DRB CASE ACTION LOG (Preliminary/Final Plat)

DRB Application No.: 11DRB - 70237

Project Name: Original Townsite

**CITY OF ALBUQUERQUE
PLANNING DEPARTMENT
July 27, 2011
DRB Comments**

**PLAT OF LOTS 13-A & 17-A  
BLOCK 49**

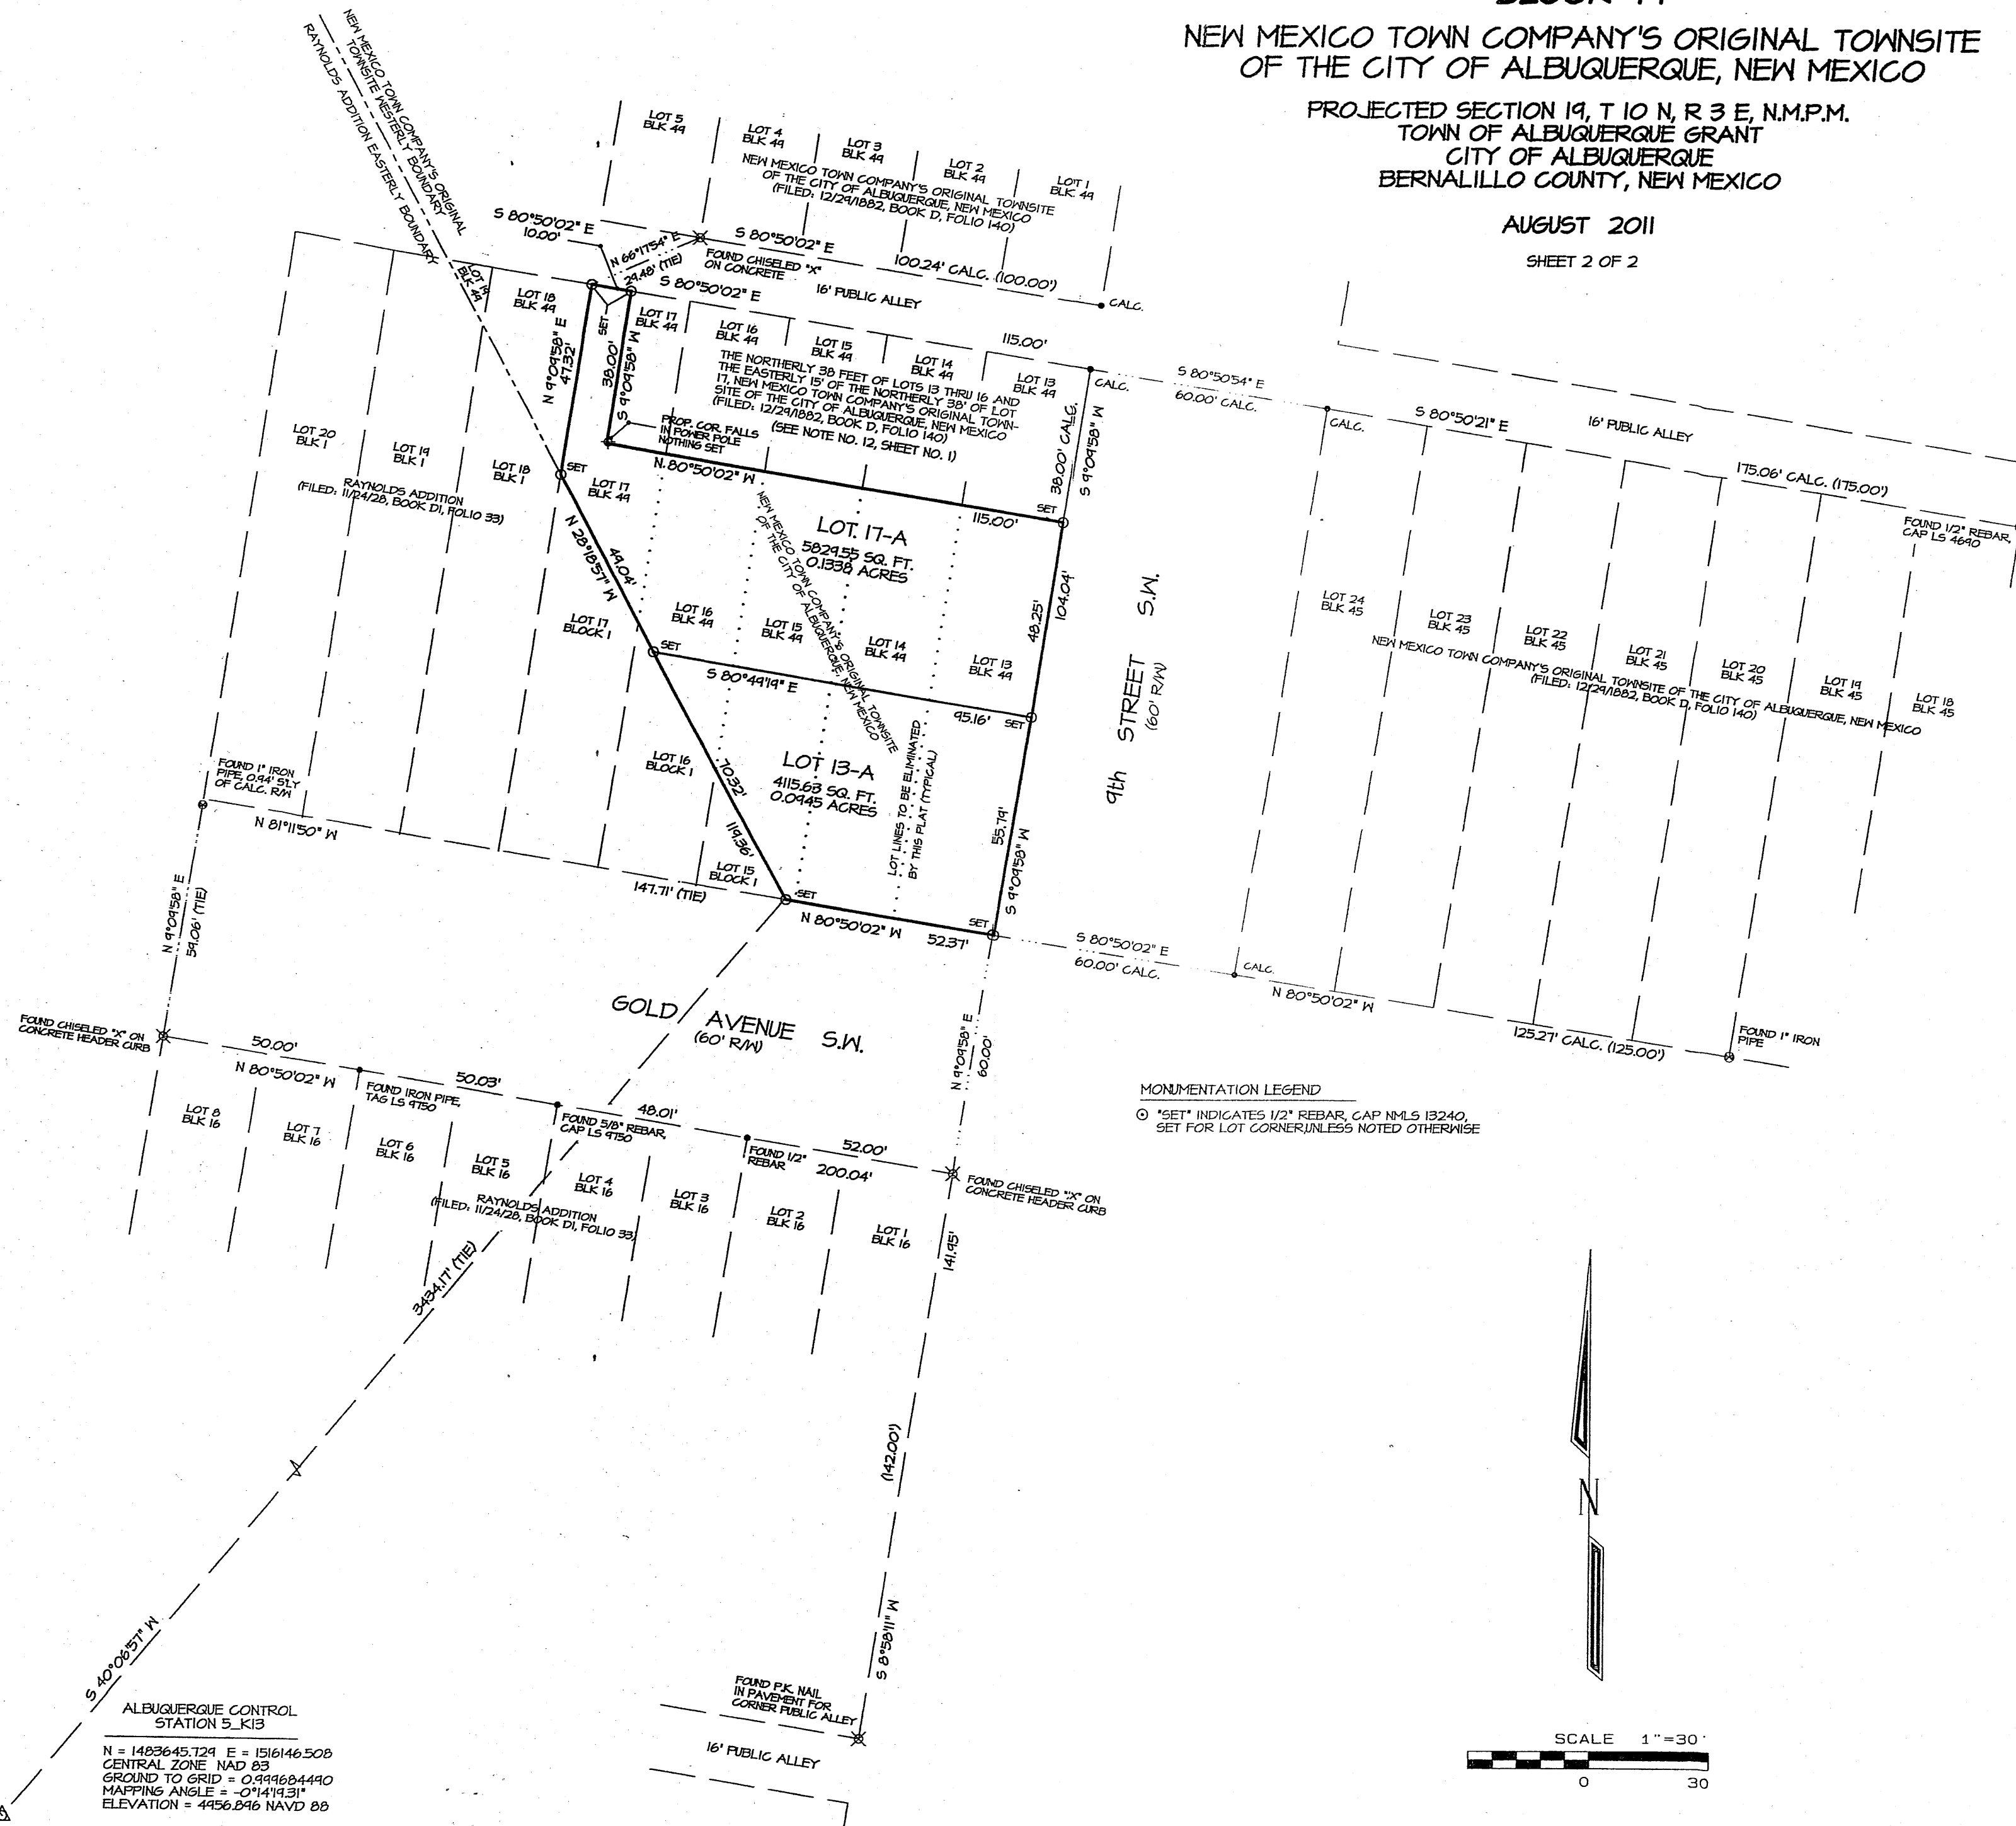
These "Portions of" lots must be documented prior to 1973 (when the City's Subdivision Ordinance was adopted), and a pre-1973 Deed must be referenced on the plat.
